Recommendation Report for Planning Permission for Works or Extension to a Dwelling

REF NO: AW/21/26/HH

LOCATION: 22 Sefton Avenue
Aldwick
PO21 3BN

PROPOSAL: Proposed side dormer and partial garage conversion.

Proposed South Elevation

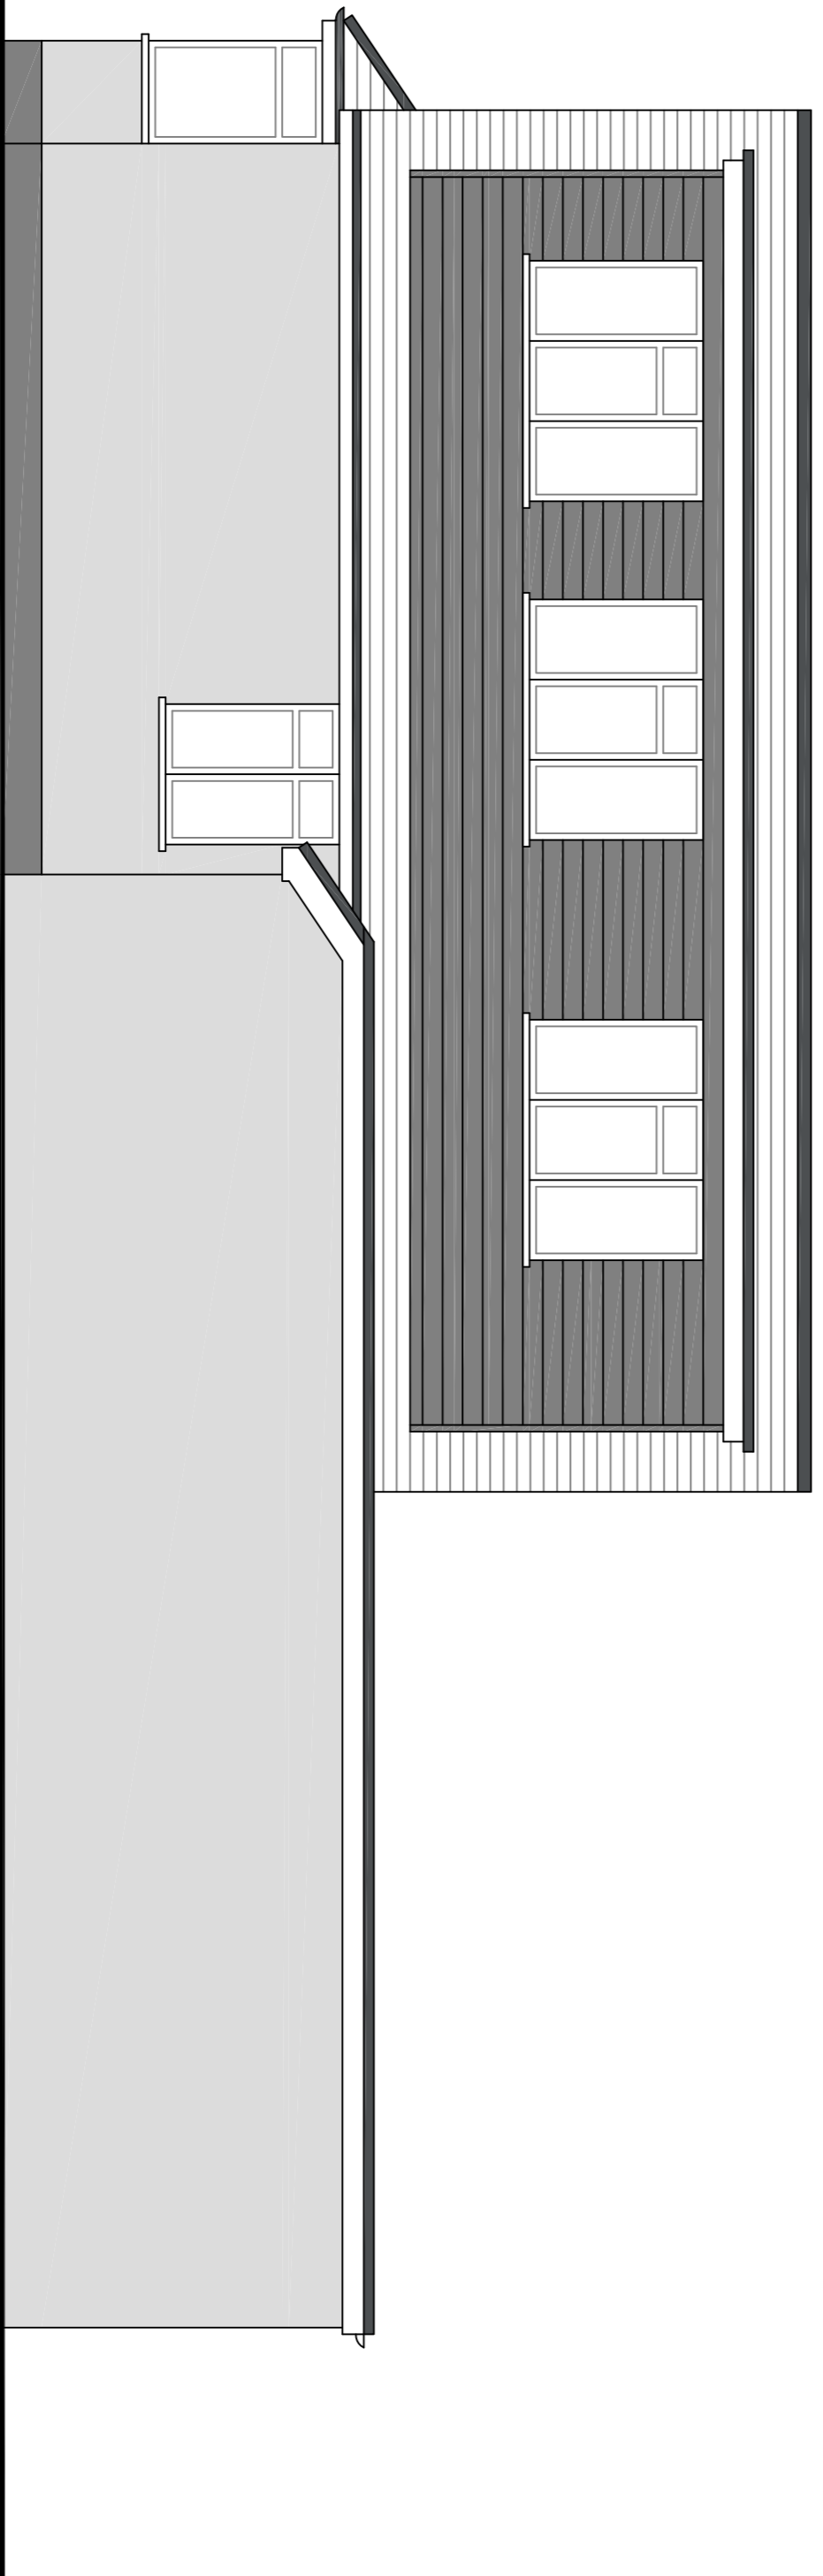
A large scale dormer is proposed on the southern roof slope. The dormer would measure approximately 9.5m in width and 3.9m in depth, with a flat roof reaching a maximum height of approximately 2.6m. External finishes would comprise cladding materials matching those of the host dwelling, ensuring visual integration in line with the Arun Design Guide (ADG). The dormer would incorporate three pairs of three-pane windows in a style consistent with the existing fenestration, serving a proposed bedroom, stairwell, and bathroom.

Due to its scale and position, the dormer would be prominently visible within the street scene. It would extend along almost the entire length of the southern roof slope and would not appear as a subservient addition, contrary to guidance within the ADG. The increased bulk and flat roof design would appear visually dominant and would not reflect the character of the original dwelling. As a result, the structure would appear visually prominent and somewhat obtrusive, resulting in a degree of harm to the visual amenity of both the host dwelling and the wider locality.

The proposed southern (side) dormer would contain three three-pane windows at first floor level. The two windows positioned closest to the front elevation would face the blank side roof slope of the neighbouring dwelling. These openings would not serve habitable rooms and would not result in any harmful overlooking or loss of privacy.

The rearmost window within the dormer would serve a bedroom and would provide oblique views towards the neighbour's rear garden, patio area and an existing rooflight. As there are currently no openings within the southern roof slope of the host dwelling, and the introduction of this window would give rise to a material increase in overlooking. To protect the residential amenity of No. 20 Sefton Avenue, it is therefore necessary and reasonable to ensure that this window is obscurely glazed and

non-openable below 1.7m from finished floor level. A planning condition is attached to ensure this window would be retained in this condition in perpetuity.

- 3 The rearmost first floor level window within the southern flank elevation of the host dwelling shall at all times be glazed with obscured glass to a level equivalent to Pilkington Level 3 or nearest equivalent standard and non-openable below 1.7m above finished floor level. This arrangement shall be permanently retained thereafter.

Proposed Ground Floor Plan

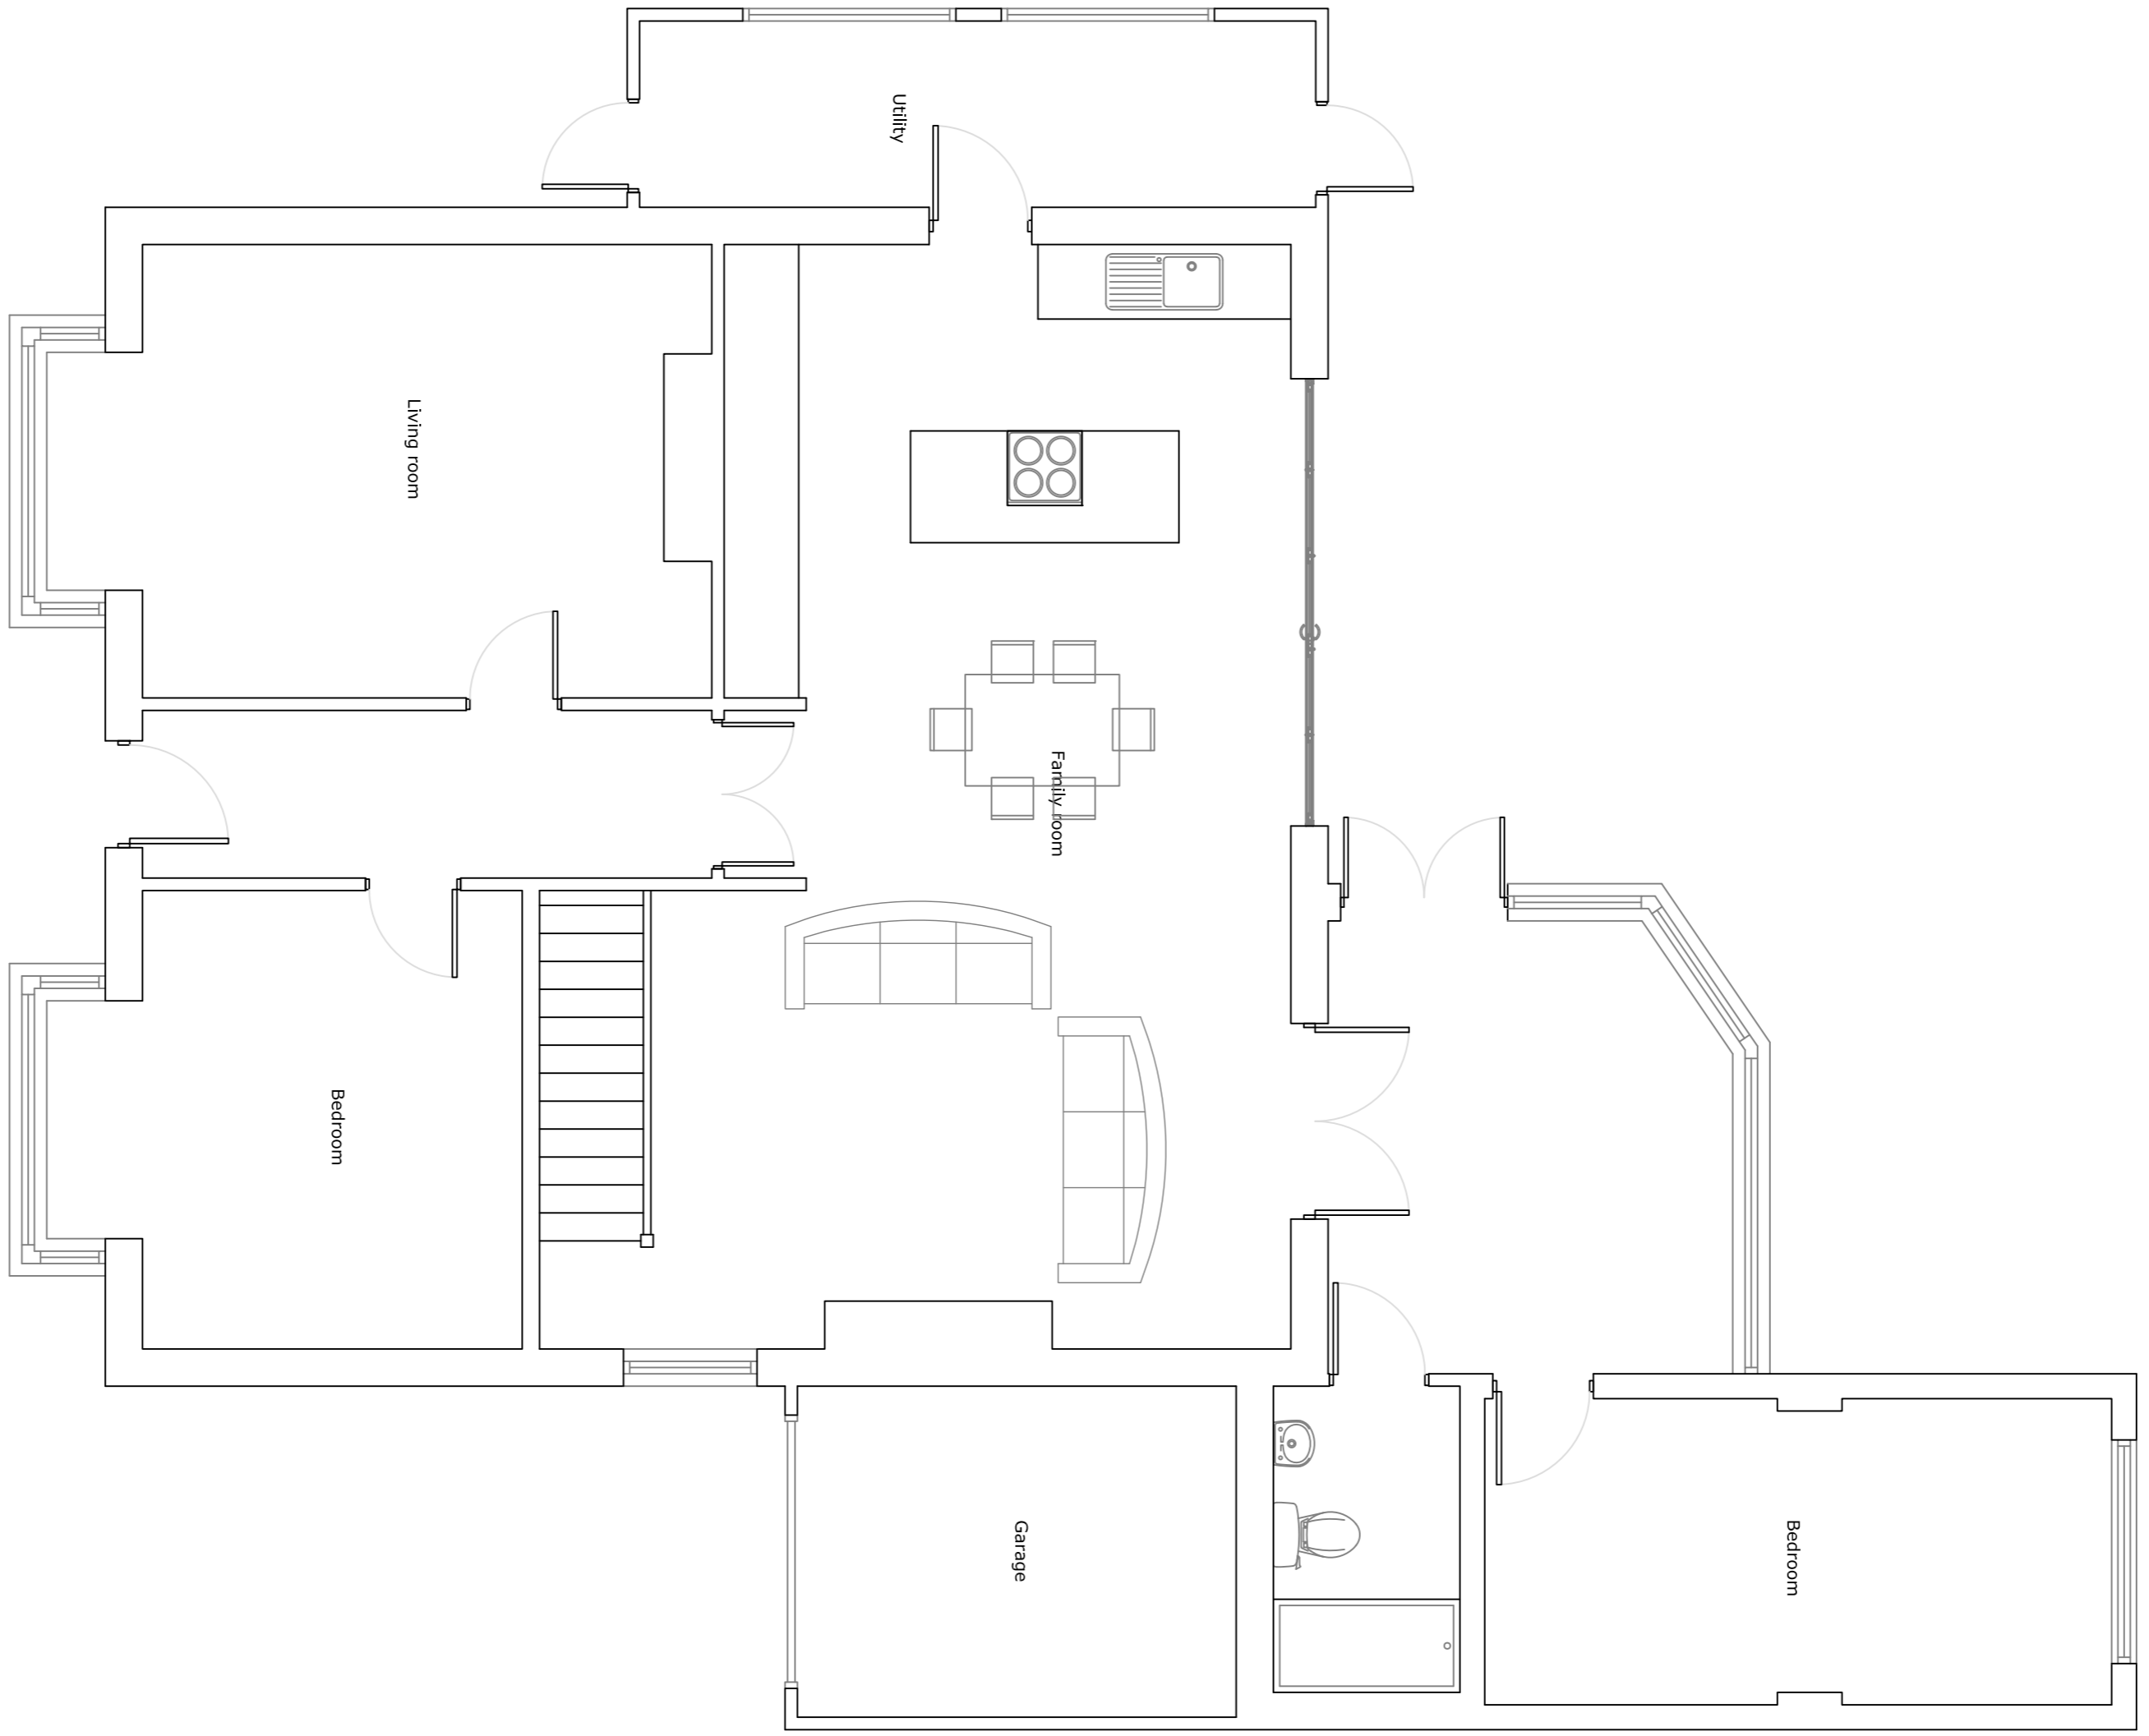
The proposal also includes the partial reduction and reconstruction of the garage to facilitate a new bathroom. As these works would not alter the external appearance of the garage, and as the structure would continue to present as a garage, these internal works would be acceptable.

The proposed garage conversion would not alter the existing footprint of the structure. As no windows are proposed, and as the external appearance would remain unchanged, the conversion would not result in any adverse impacts on neighbouring amenity.

The application site is located within Parking Zone 2 and as per the Arun Parking Standards (APS), 3 bedroom dwellings are required to provide 2 parking spaces. It is noted that the existing garage would not meet the best practice minimum internal dimensions for garages. The ADG states that garages should measure at least 6m by 3m internally to qualify as a parking space. As such, the existing garage cannot be counted towards the parking provision and therefore its loss to a habitable space would be acceptable.
